DECISION DELEGATED TO HEAD OF PLANNING

Application No: H09-0377-23 **Applicant:** Mr & Mrs Taylor
Proposal: Erection of detached garage
Location: Woodhouse Farm Hurn Road Holbeach Hurn
Terminal Date: 15th June 2023

SOUTH WEST ELEVATION

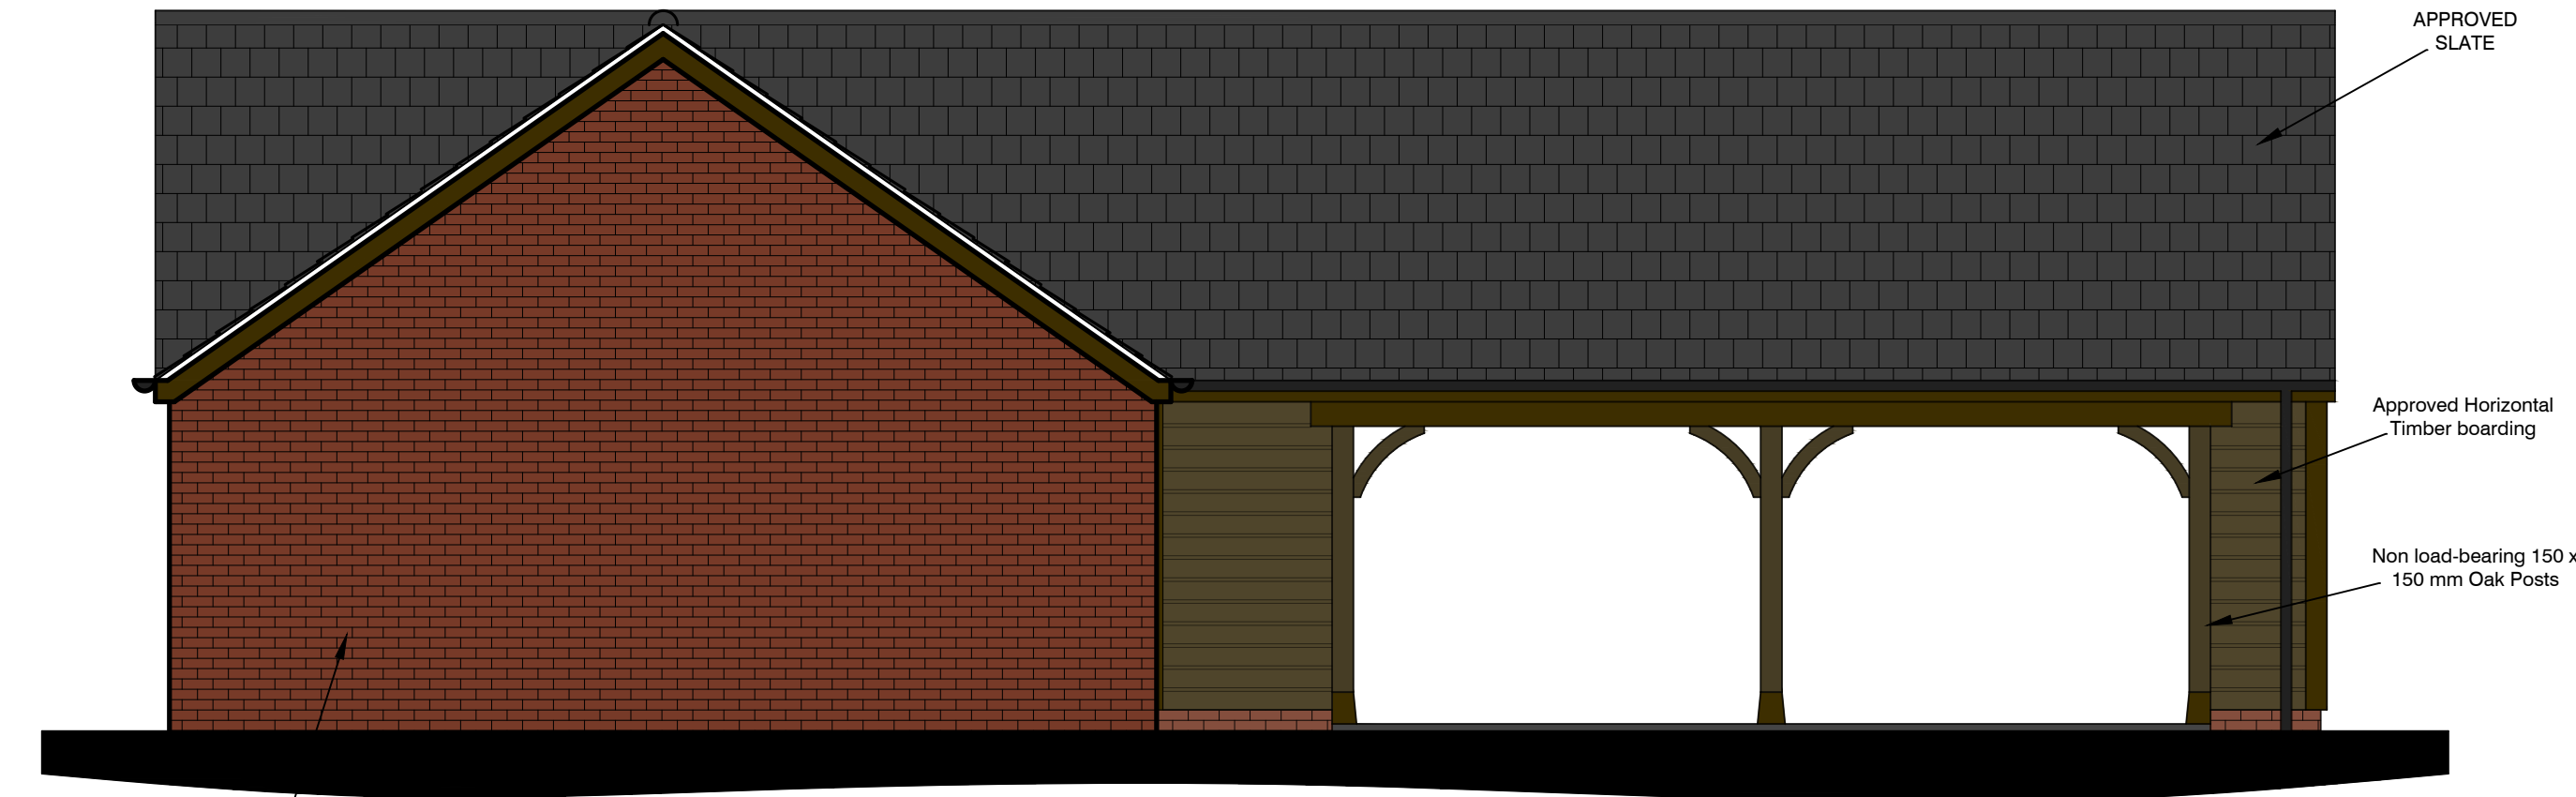
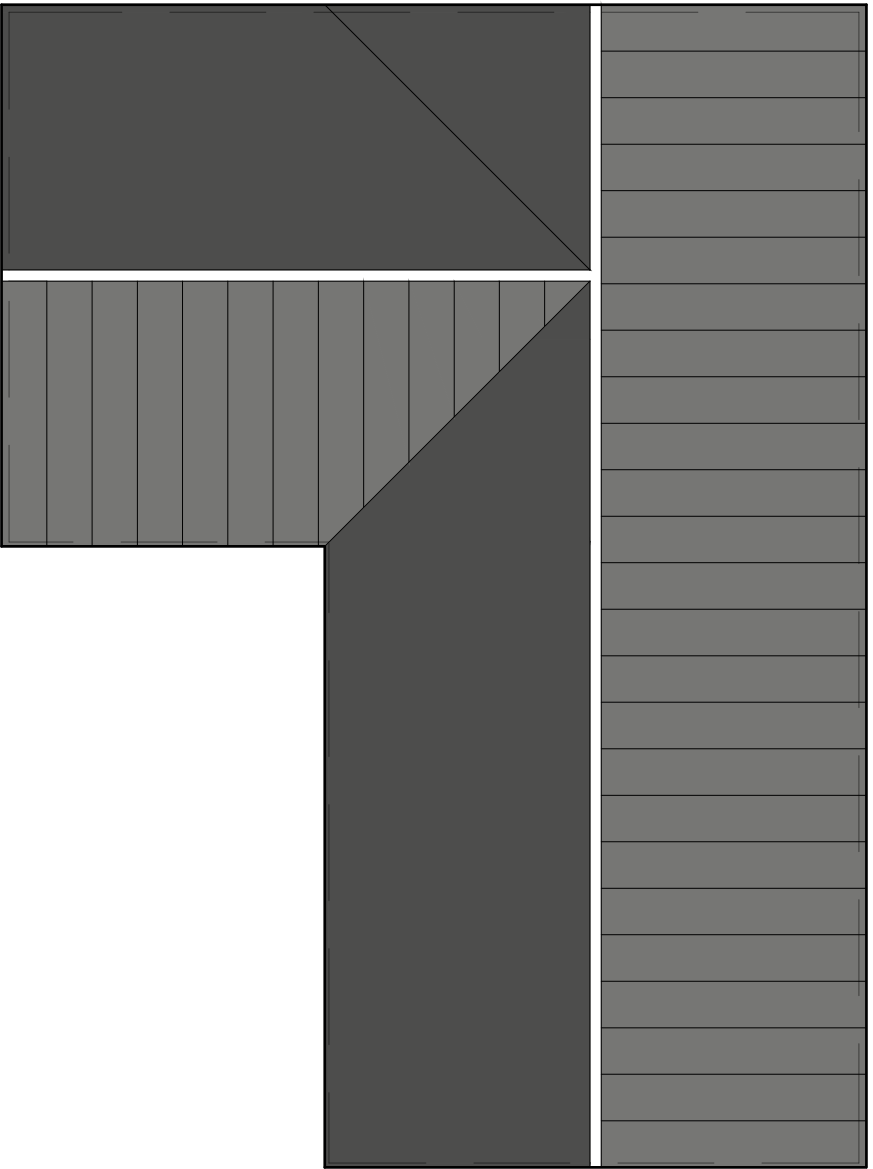
The proposed detached garage will be situated to the west of the existing house approximately 4.8 metres away. It will be split into three sections internally including a 'Garden Store' to allow for more storage for the applicants, this will have a floor area of 7.2m by 6.4m. Adjacent to this there will be a 'Double Open Fronted Garage' with a floor area of 7.2m by 6.4m and there will also be a 'Single Garage' with a floor area of 6.4m by 4.2m. The total floor area of the proposal is 121 metres squared. The dimensions of the proposal are 15178mm (length) at the rear of the garage, 11240mm (width), 6965mm (width) and 6965mm length for the single garage section.

The proposed design is in keeping with the existing dwelling on site as the brickwork has been selected to match that of the existing house and the slate is also of a similar design and colour. This ensures that the garage won't stand out or look out of place compared to the dwelling. As the existing dwelling and this proposed garage will be the only properties on the site it will also be in keeping with the locality of the area.

It can be considered that the overall size of the garage is very large and possibly not completely proportionate to the main house. However, the floor area is significantly smaller than the main house despite the length and width of the garage, the previous application on this site for a dwelling and a garage was approved with the total floor area of the garage being 126 metres squared for a 2 storey garage. This new garage is smaller in size when compared to what was originally approved. Therefore the dimensions and measurements are considered to be proportionate to the dwelling and it complies with Policies 2 & 3 of the SELLP and Section 12 of the NPPF.
